Our Ref: C222234

Application: LU/386/17/PL

Proposal: Use of land as site for residential mobile homes consisting of 14 pitches

Location: Land east of Torri House, Old Mead Road, Littlehampton, BN17 7PU

Site Plan	
Date	November 2017
Scale	1 : 500 @ A3
Sheet	MJS/11-2017/ PL47-02

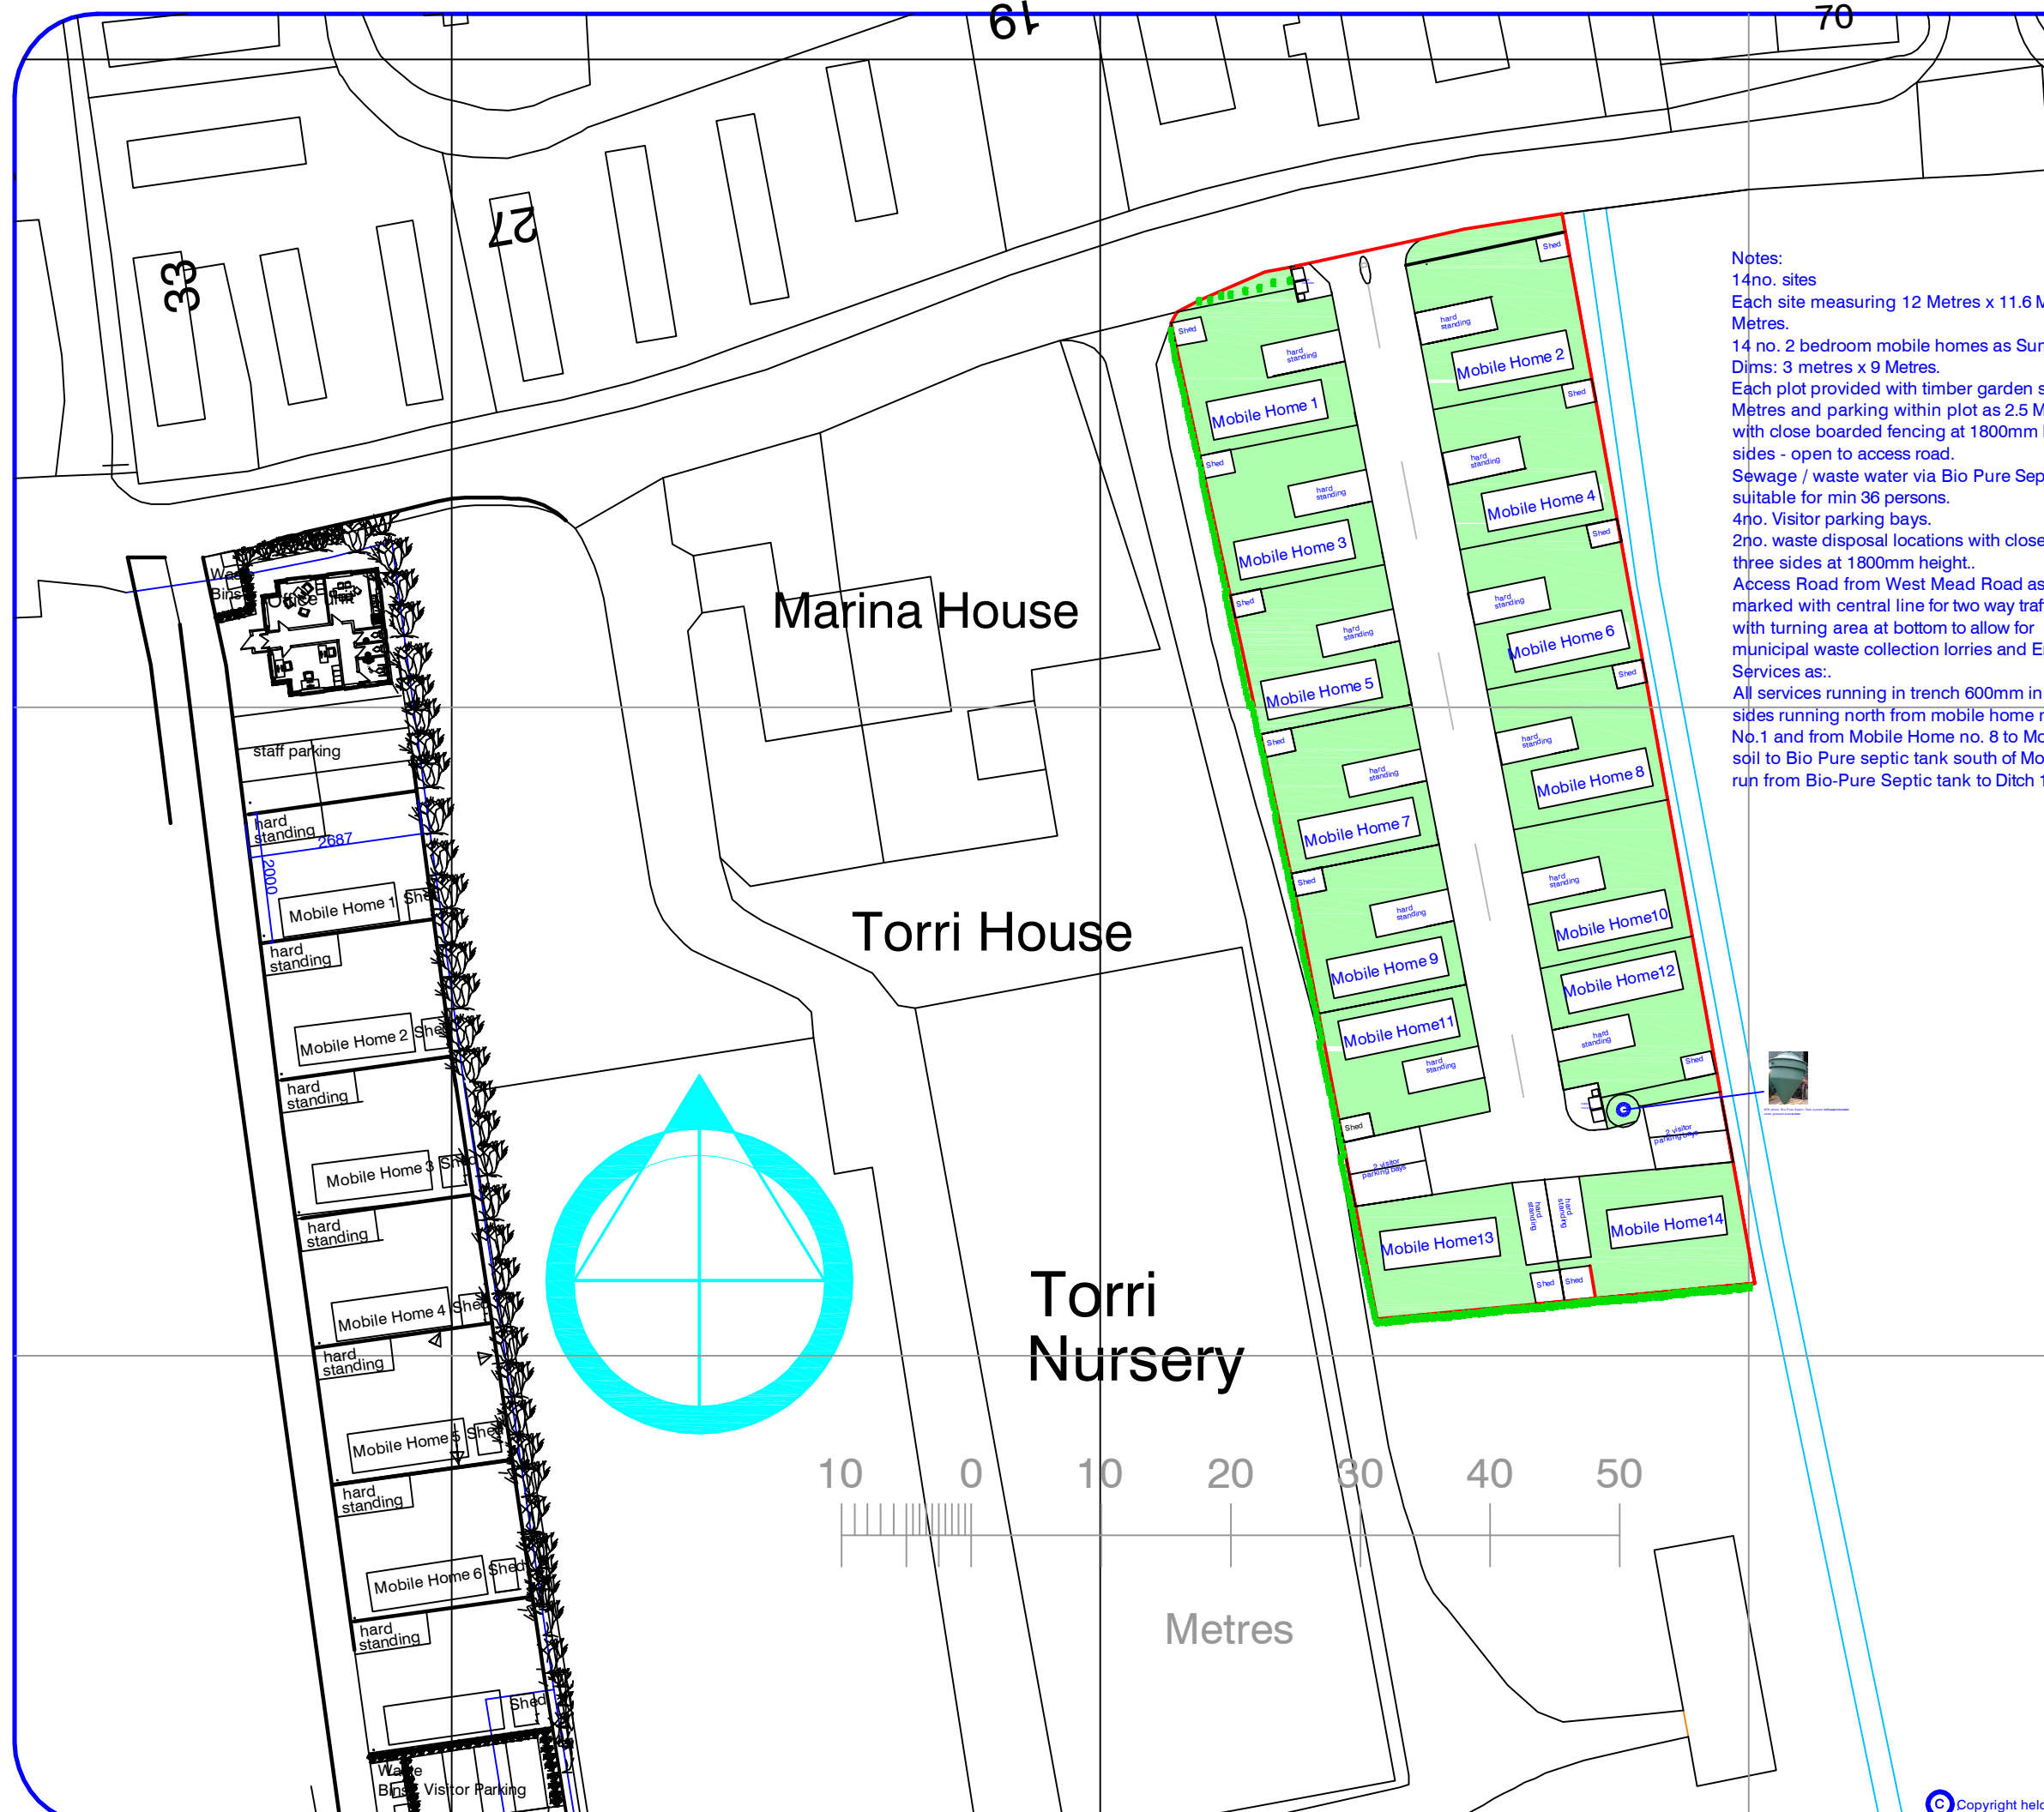
Design & Lighting - The plans do not address many of the above points or show that standards are unlikely to be met. Of particular note:

- There does not appear to be any lighting provision to meet the requirement at point 8 above,
- Foul water disposal is not supported by a design capacity assessment for flows and loads – proposed unit is for minimum 36 persons but potential occupancy is for 64 persons
- Separation and boundary distances are not fully met
- Communal recreation facilities are not provided (or an explanation of their absence is not provided)
- Combustible (timber) sheds are proposed
- Pitch / hard standing construction does not appear to meet industry guidance; local ground conditions must be taken into account

3. No development shall commence until a detailed design scheme for the proposed pitches and dwellings, reflecting the recommendations of the Model Standards, has been submitted to and approved in writing by the Local Planning Authority. Any works which form part of the scheme approved by the authority shall be completed before any permitted dwelling is occupied unless an alternative period is agreed in writing by the authority.
